Our ref: 20003

15th January 2020

**OBJECTION
UNIVERSITY OF NEWCASTLE CITY CAMPUS CONCEPT PLAN
CONCEPT APPLICATION – STATE SIGNIFICANT DEVELOPMENT
SSD9262**

Figure 4 Revised Civic Lane Section

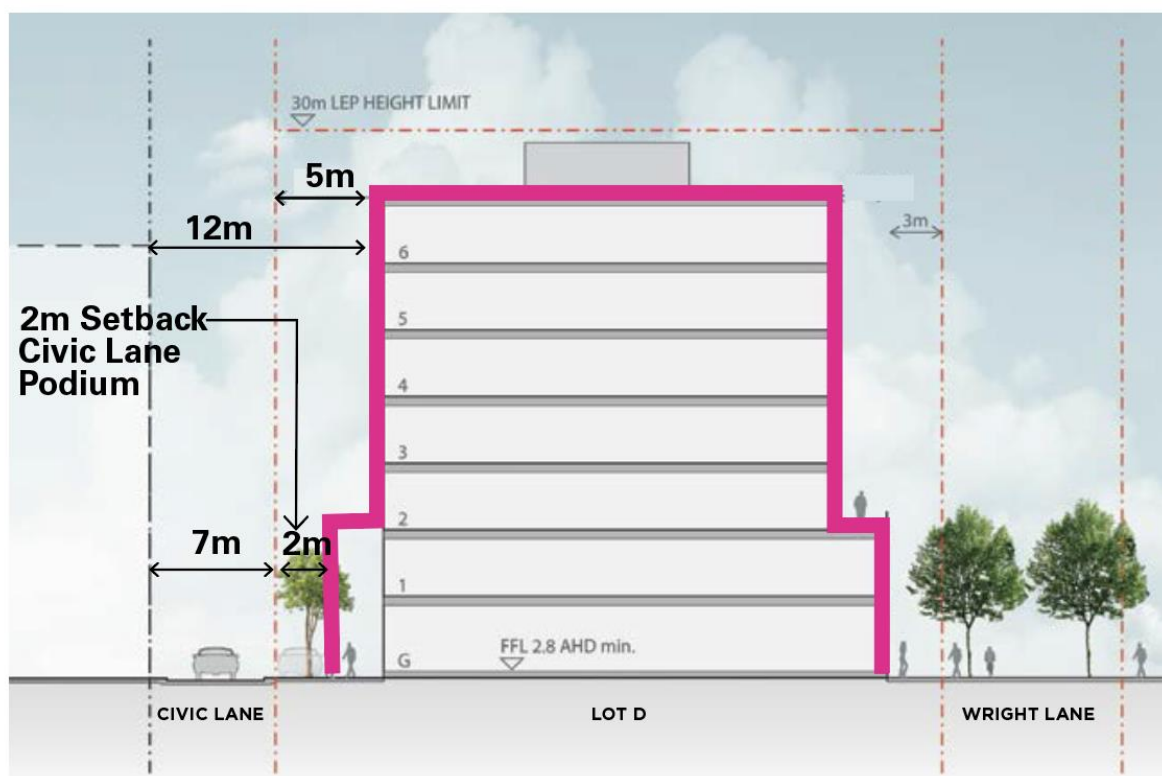
- Both the height and Floor Space Ratio controls are maximum development standards. They provide an indication of what may be a maximum height or building floor area when a detailed analysis has been completed on the likely impact of the development. Where site analysis identifies a clear impact to a neighbouring land use, the design must reflect and respond to these conditions;
- The concept proposal has sited its highest elements, including those elements that will require an encroachment of the maximum building height, along the southern boundary of the site. This, in

turn, creates the greatest amount of impact to 522 Hunter Street (and Hunter Street buildings more generally).

- Such an outcome is deemed to be inconsistent with best practise planning outcomes, where increased setbacks and reduced heights are generally implemented to minimise overshadowing impacts along southern boundaries. This is particularly the case where development has the potential to impact on the amenity of existing development. The applicants own section demonstrates this siting (**Figure 3**) and no explanation is provided (beyond an intention to seek a maximum development envelope to reflect the maximum controls) for this outcome.

It is my view that an alternative Building Envelope scheme could be developed that will readily achieve the design principles for the site whilst maintaining a reasonable level of solar access, being compliance with the Apartment Design Guide Controls, to 522 Hunter Street. This could include reconsideration of the massing of Building B and/or increased separation between Building B and D, subject to investigations by the applicant. It is noted that improved sunlight access is unlikely to be achieved through increased building articulation at the detailed design phase should the proposed building envelopes be approved.

Figure 5 Overshadowing of previously proposed building envelopes

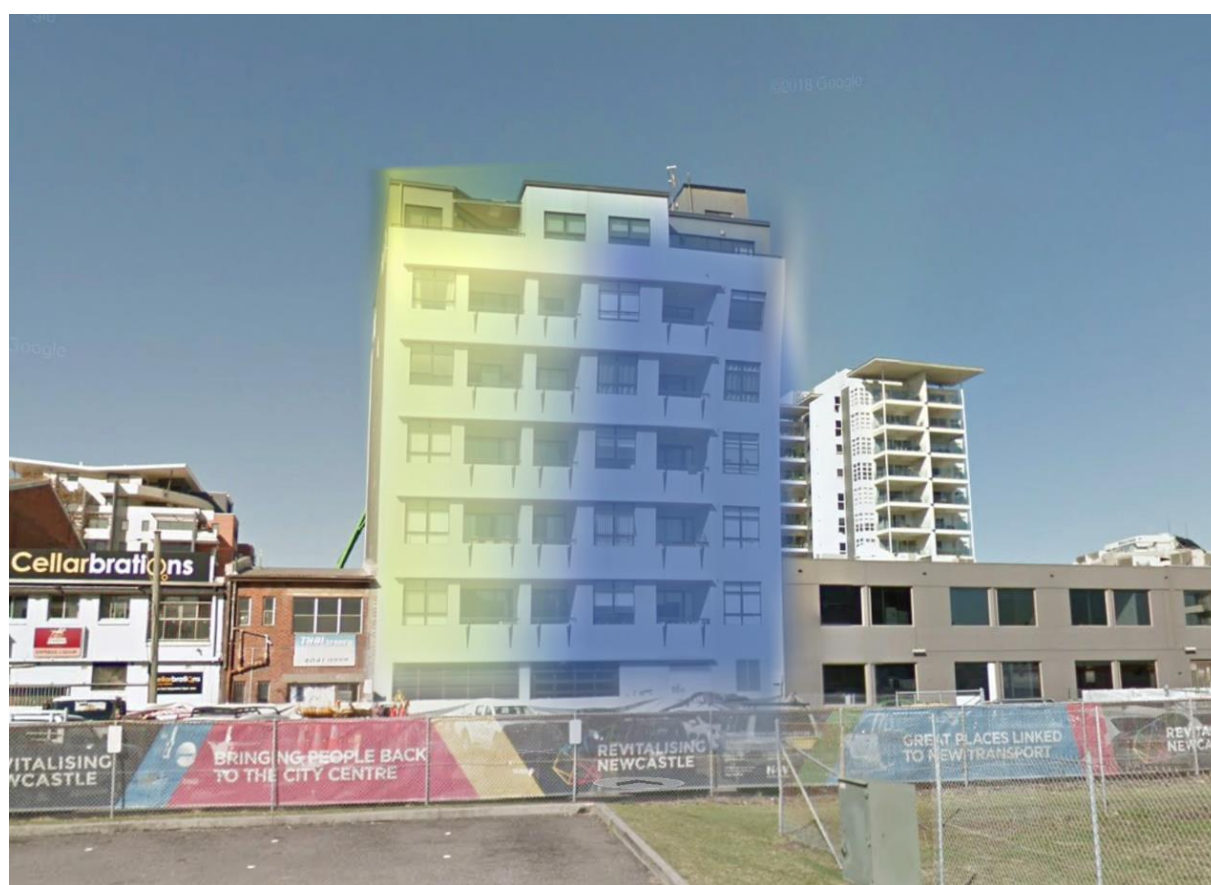
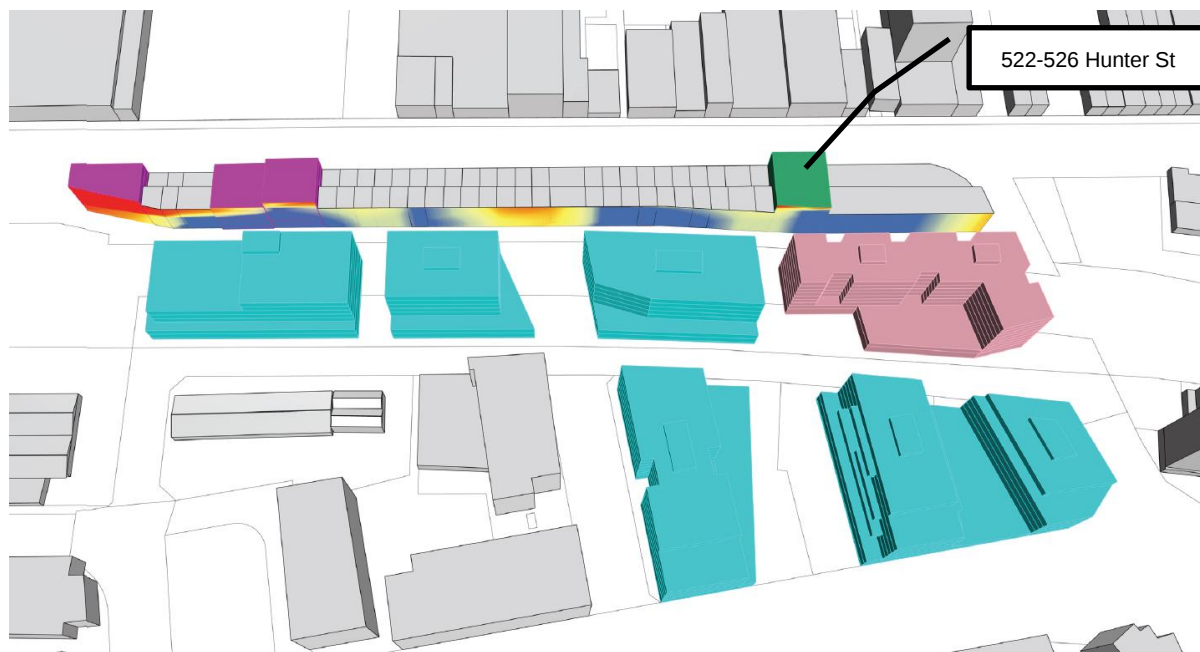
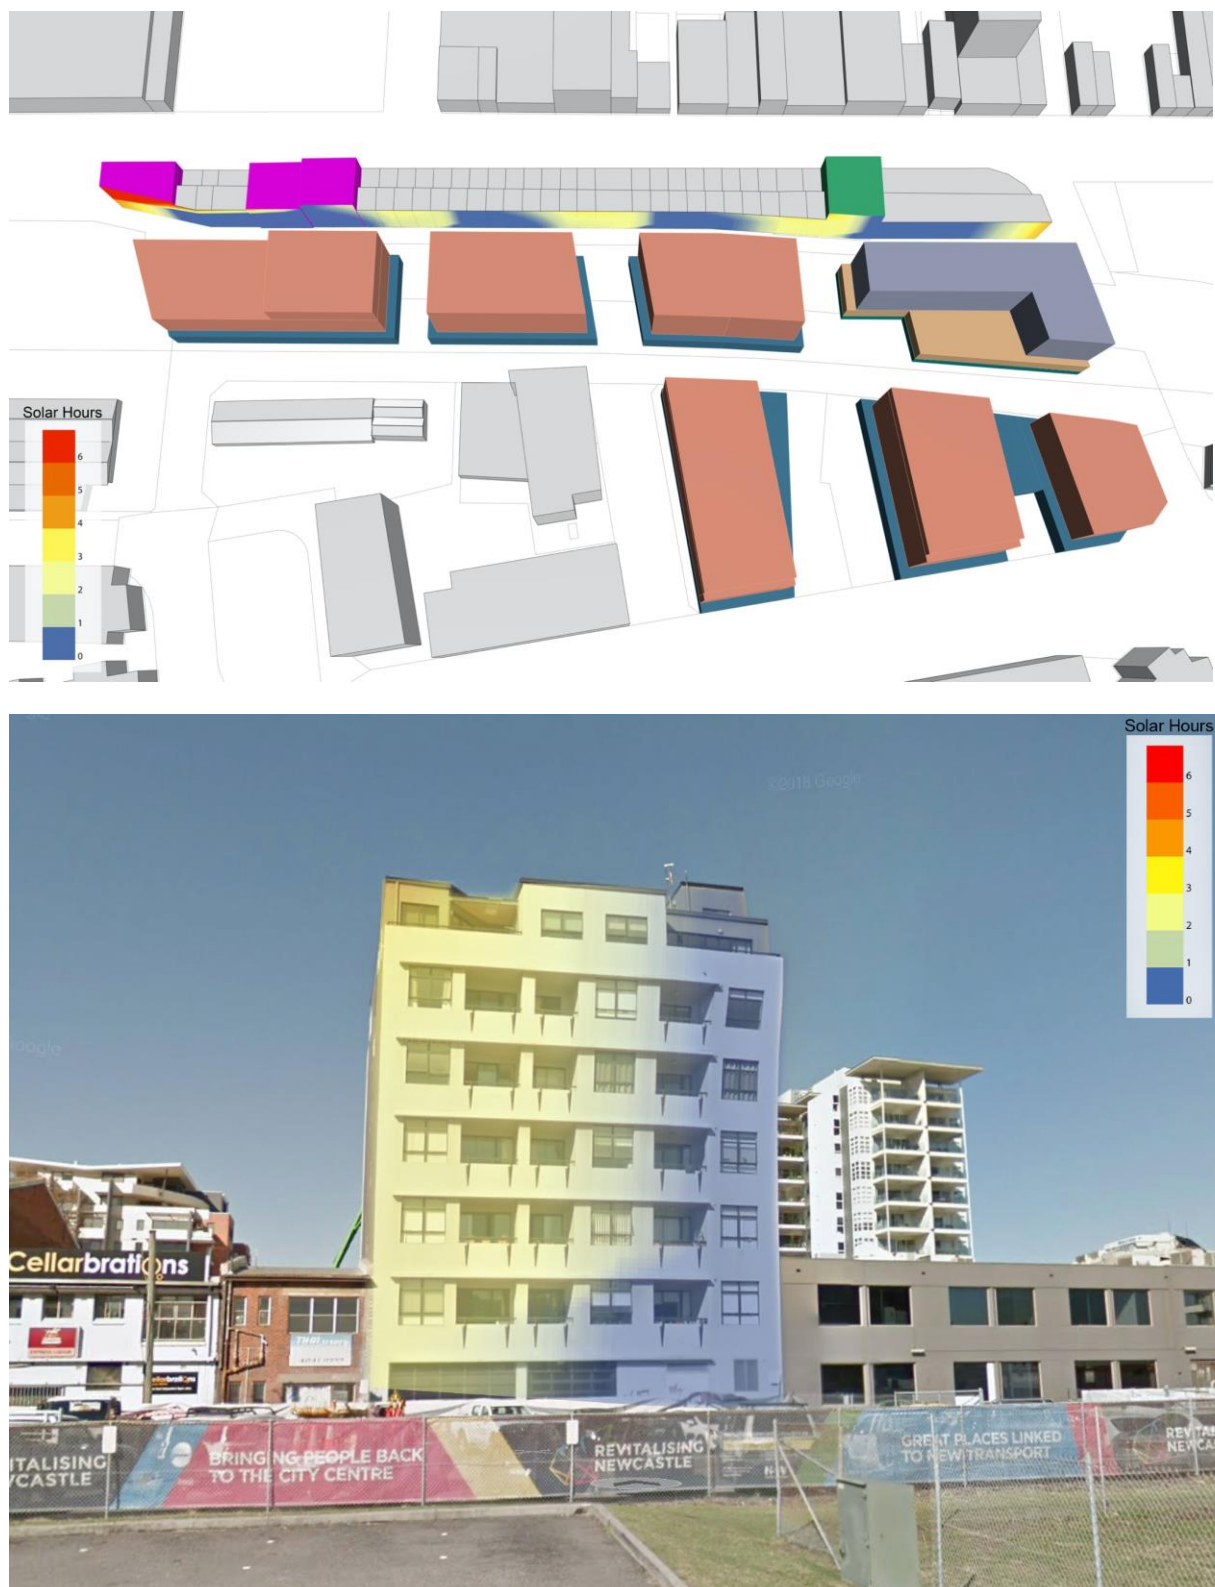
The shadow modelling provided by the applicant indicates that nearly all north facing units within 522 Hunter Street will no longer receive 2 hours of sunlight. The building will predominately be in complete shadow, refer to **Figure 2**.

Figure 2 – Extract from Shadow Analysis

The shadow diagrams would appear to contradict the Environmental Impact Statement assertion that *buildings along Civic Lane are set back 6m to provide appropriate separation between potential future residential development along Hunter Street and to minimise shadowing impacts* (Page 39).
